DELEGATED DECISION TO DETERMINE APPLICATIONS FOR LISTED BUILDING CONSENT

Reference No:	2026/44/90763/E
Site Address:	Yew Tree Farm, The Village, Farnley Tyas, Huddersfield, HD4 6UQ
Description:	Discharge of details reserved by condition 20 (external works) on previous permission 2021/93007 for Listed Building Consent for conversion of existing barn to form 8 dwellings, erection of 9 dwellings, demolition of redundant agricultural buildings and associated works (within a Conservation Area)
Recommending Officer:	Katie Chew

Condition 20 (External Works)

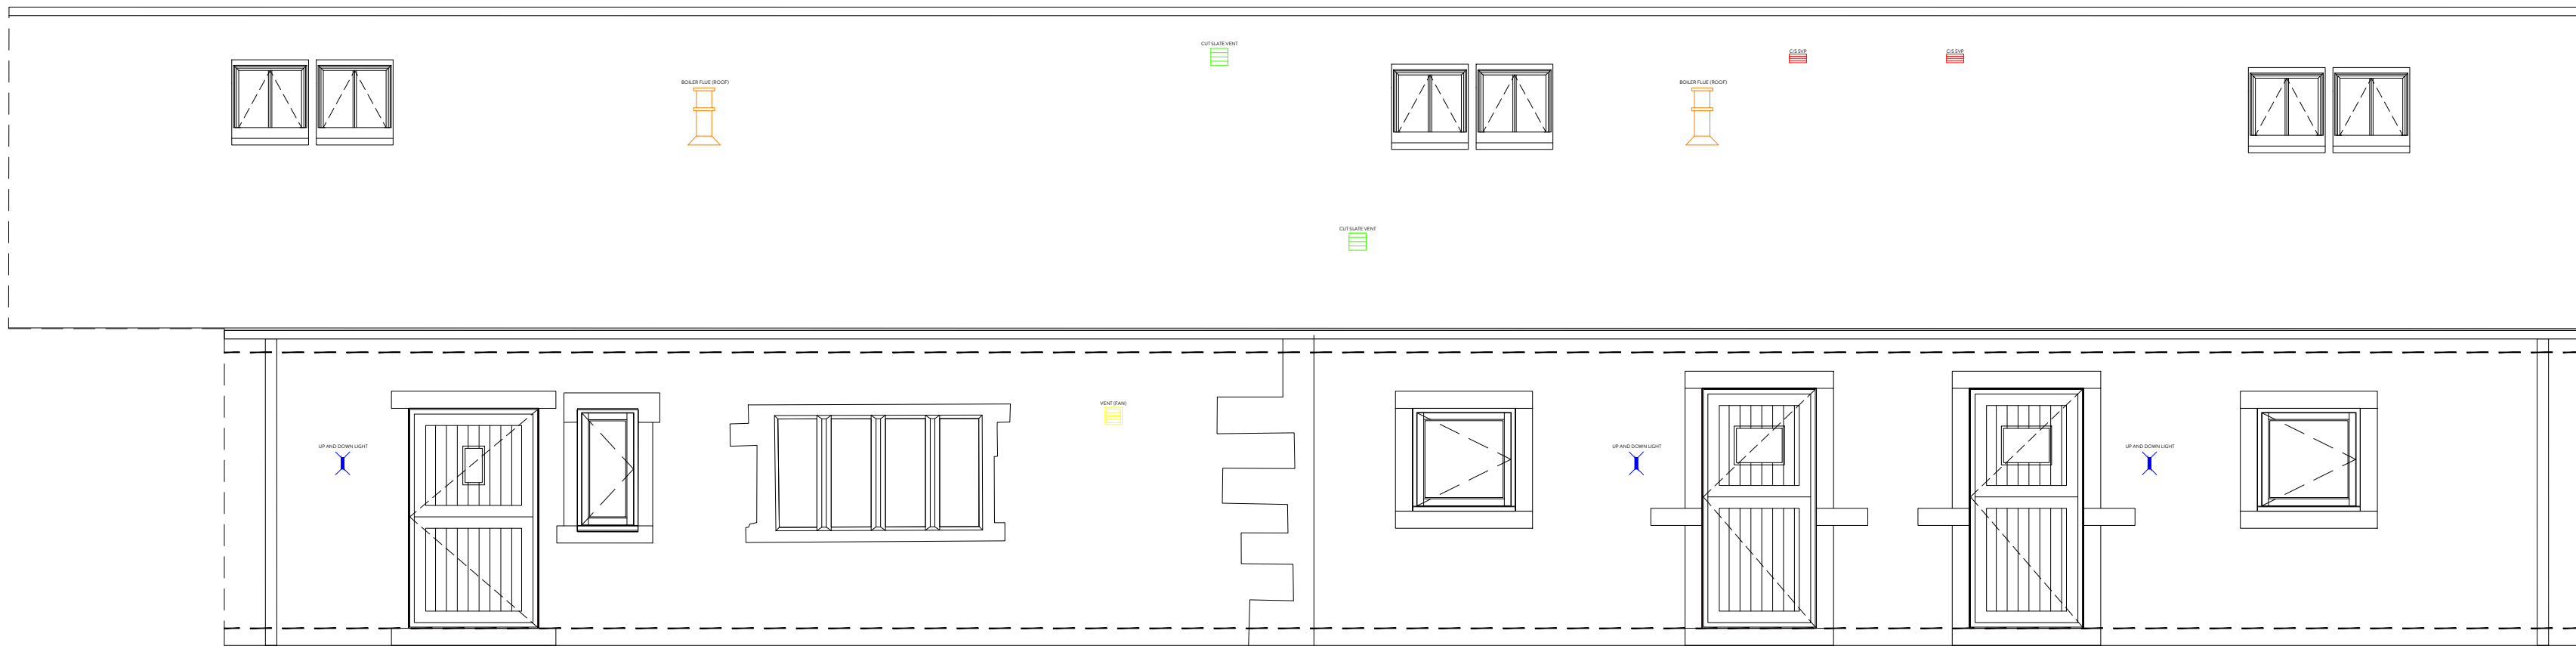
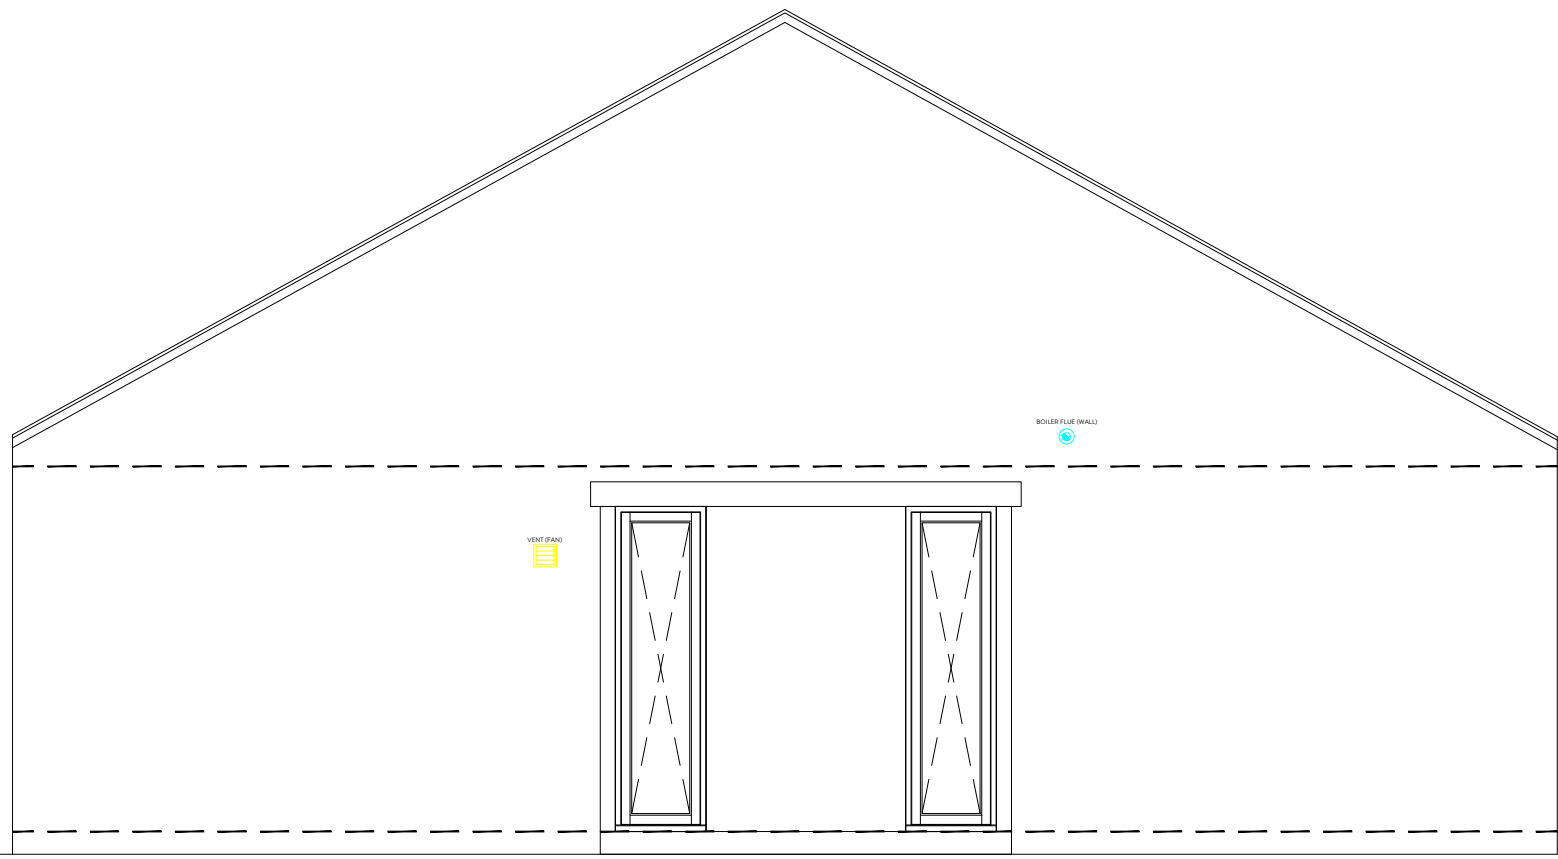
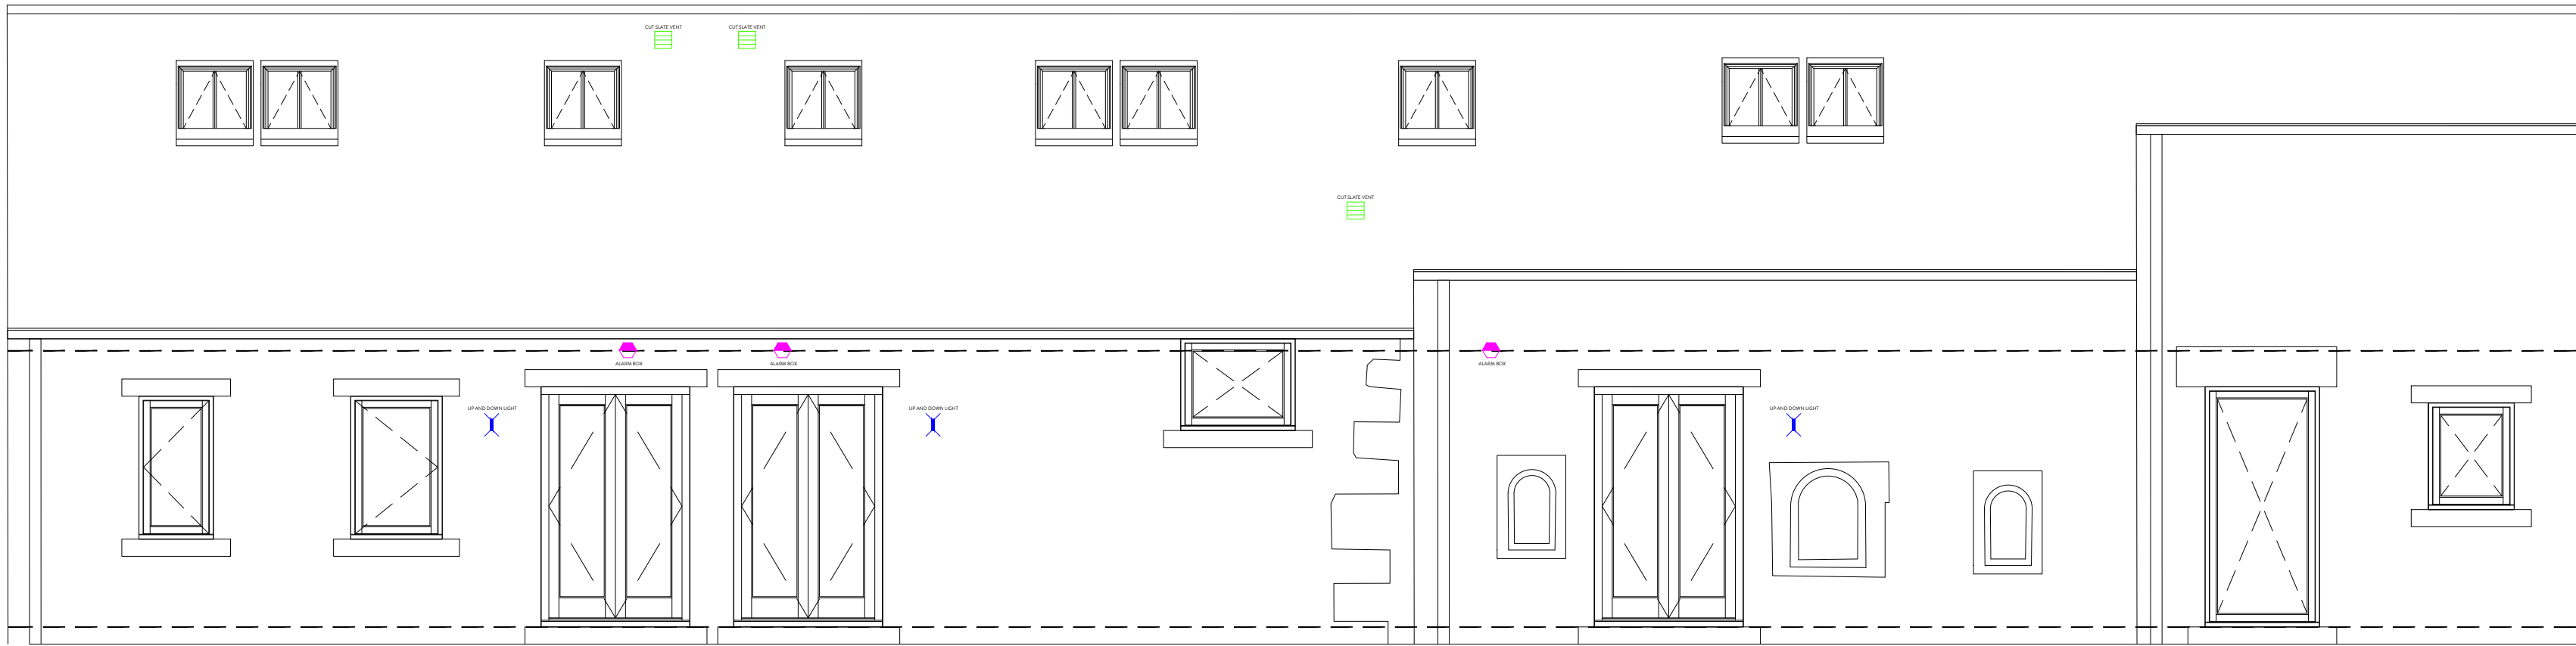
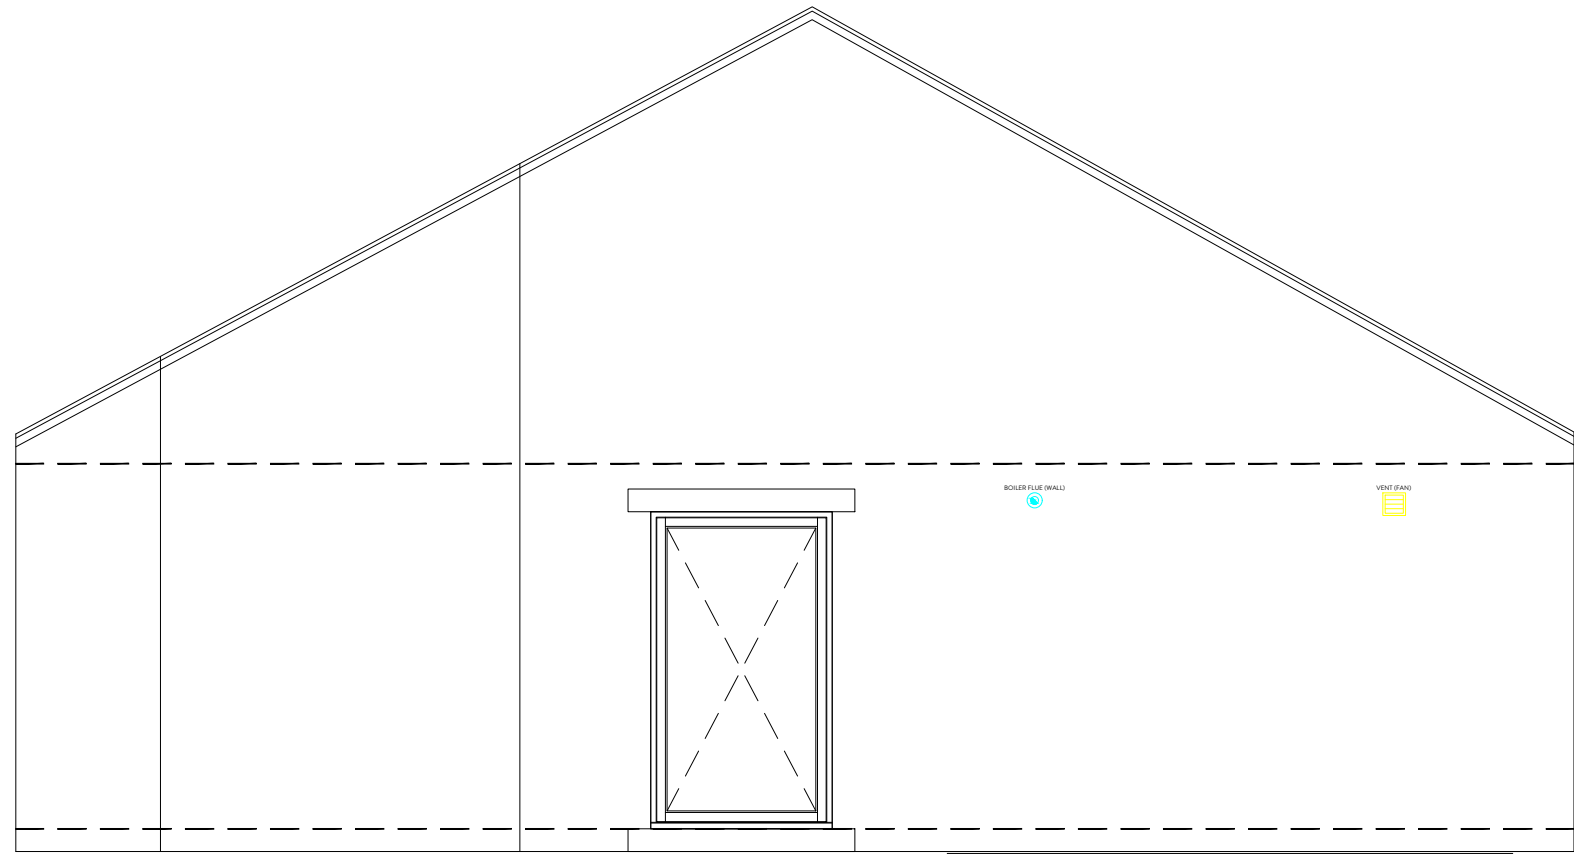
This document has been reviewed by KC Conservation & Design, who provided comments on 19/03/2026 requesting brochures for the below, with an idea on dimensions/colour finish etc.

- Soil vent pipe
- Vent (fan)
- Cut slate vent
- Boiler flue (wall)
- Alarm

- Up and down alarm
- Boiler flue (roof)

I confirm that these details are acceptable. The plans and photographs are useful to explain the details of interventions proposed.
